From: Kathryn Welch
Sent: 27 January 2022 13:24
To: 'Andy ashton' [REDACTED]
Subject: RE: 102 Middleton Road - M/107/21/HH

From: Kathryn Welch <Kathryn.Welch@arun.gov.uk>
Sent: 25 January 2022 15:10
To: Paul Scamans <Paul.Scamans@arun.gov.uk>
Subject: FW: 102 Middleton Road

The applicant has now amended their plans to show 1m's worth (overhang up towards ridge) of tile finish to the affected area of roof. The rest of the proposed thatch, along with the existing construction, will be constructed using the Dorset method. I attach plans of the latest proposal showing the alterations to the finish. It can be seen that most of the western elevation will now have 1m of tile finish with thatch above, there will be a small amount of return from the thatch covering on the southern elevation.

Side Elevation

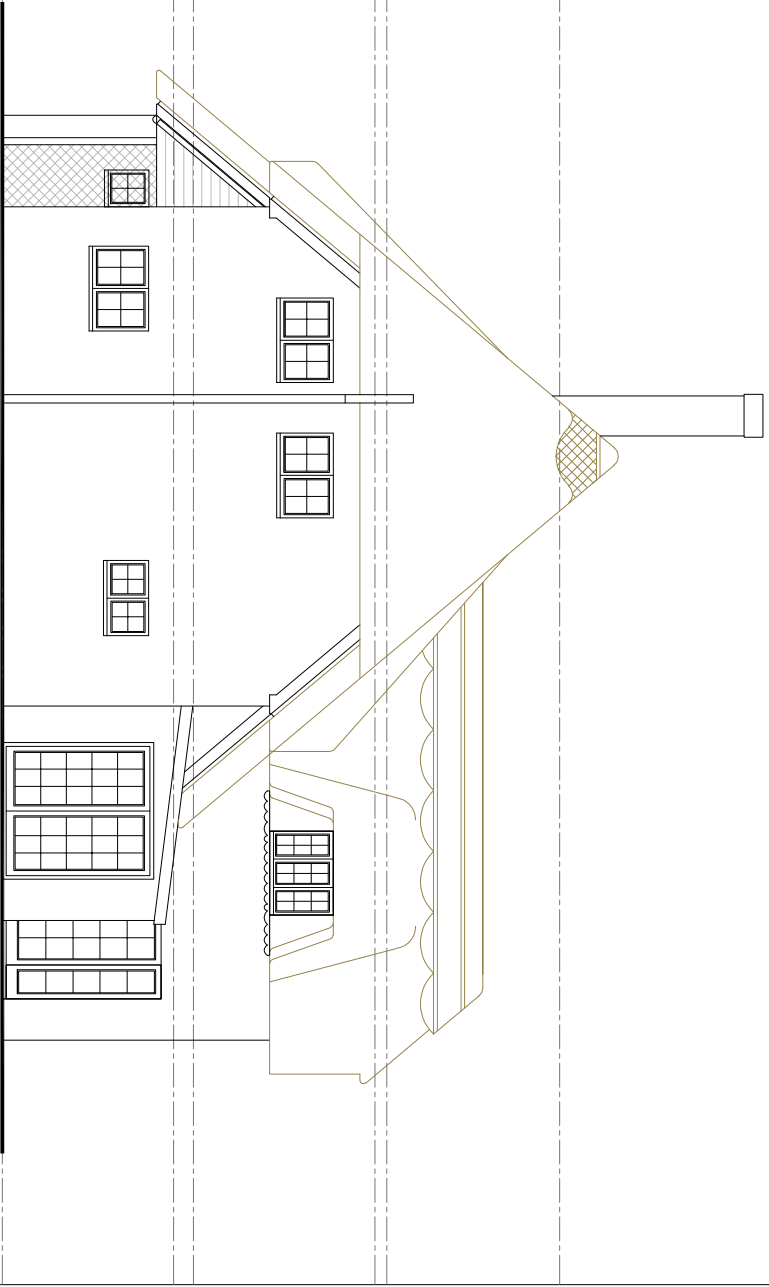
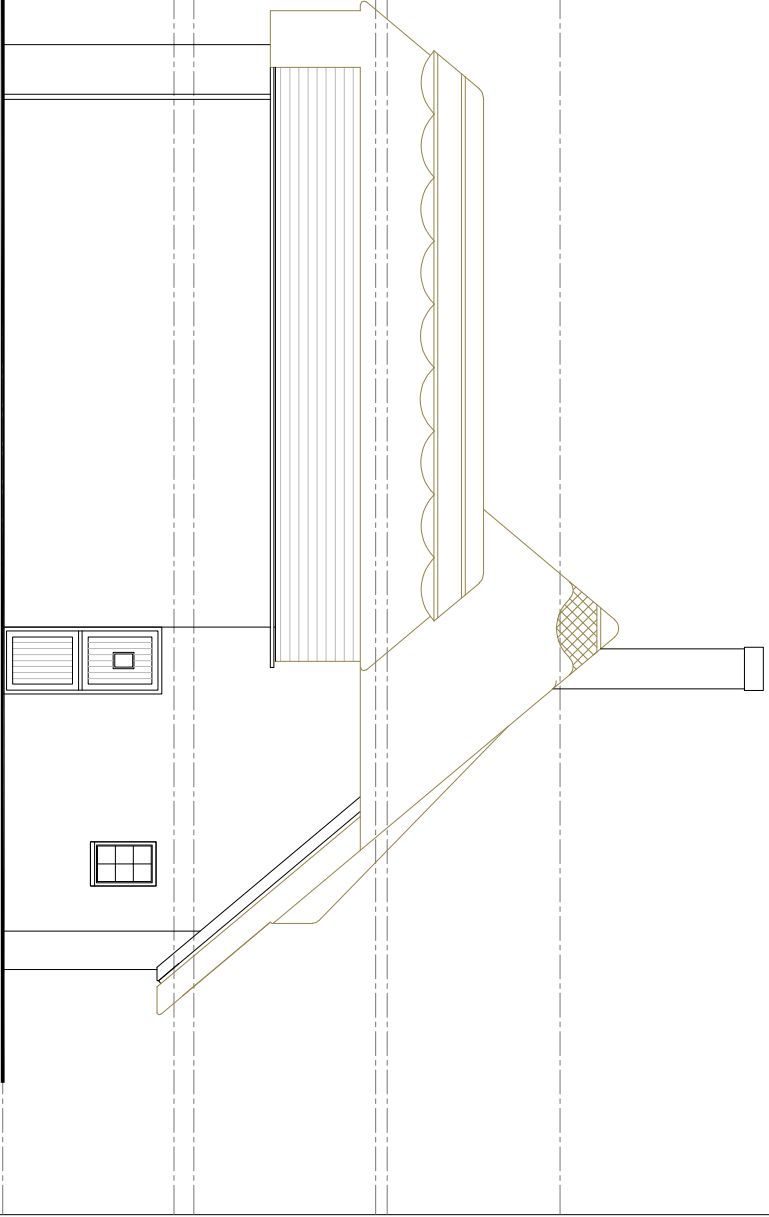
The remaining issues would be of a practical nature, e.g. constructing and supporting the narrow strip of thatch along the rear edge (see side elevation), creating a weatherproof transition between the thatch and tiles (sufficient overlap), creating the horizontal section of valley between bedroom 4 and the new bedroom (item raised in a previous email).

Roof Plan

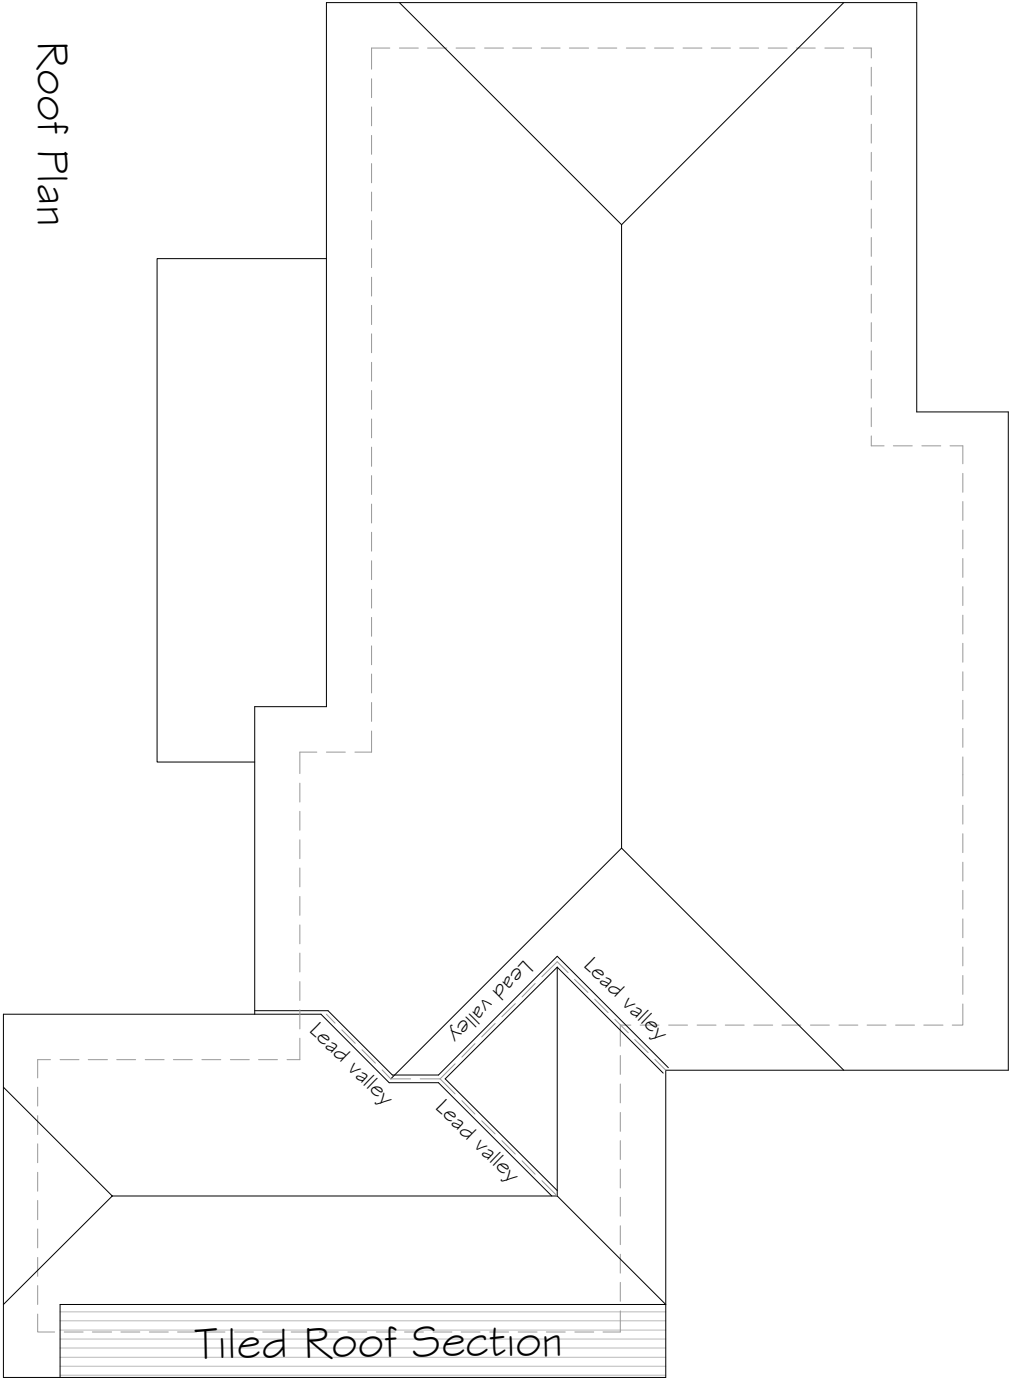
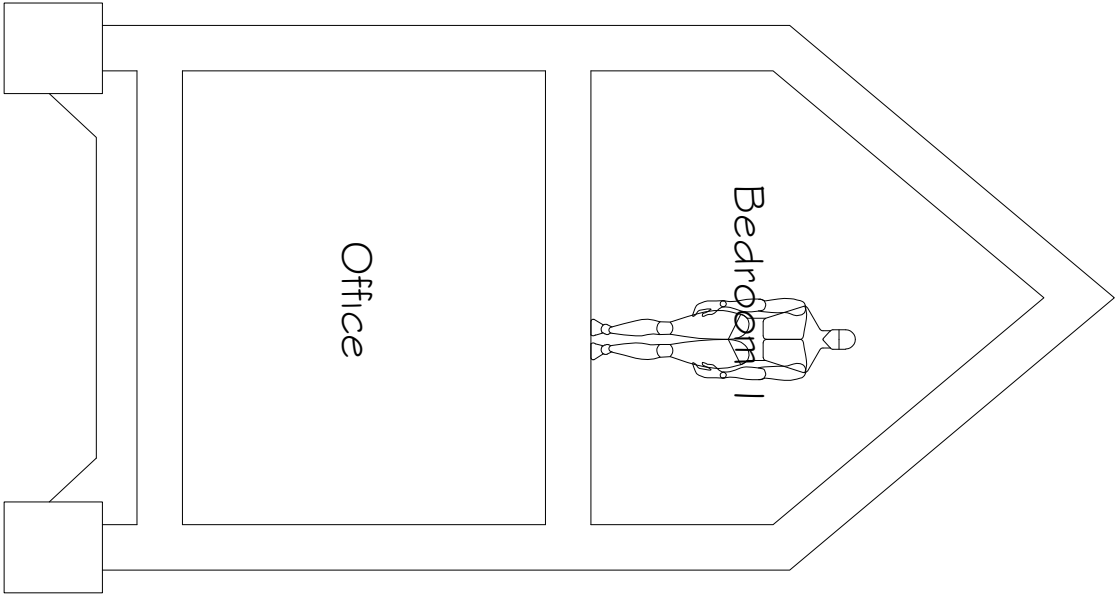
There will be a valley in between your existing roof and the proposed, unlike tiles to two can't just abut each other with a small amount of lead work to weather the roof, as the thatch will rot. As I've now discovered each element of the thatched roof needs to have a complete eaves and overhang detail, to enable rainwater to drain away freely. So the two elevations i.e. of the south facing roof and western return, will never meet as they will be two separate roof planes (you'll probably have a much larger expanse of leadwork when compare to a tiled roof) but this will need to be shown on you planning application otherwise you will not build the roof to plan.

He suggested that you get a thatcher to think about the details required in relation to the horizontal and vertical points at which the tiles and thatch meet and a the valley junction between southern and western elevations, as he didn't think it was possible to build the structure as it was shown on the drawings. So he was really was more concerned that you'd have to reapply for planning as the onsite built structure wouldn't accord with approved plans.
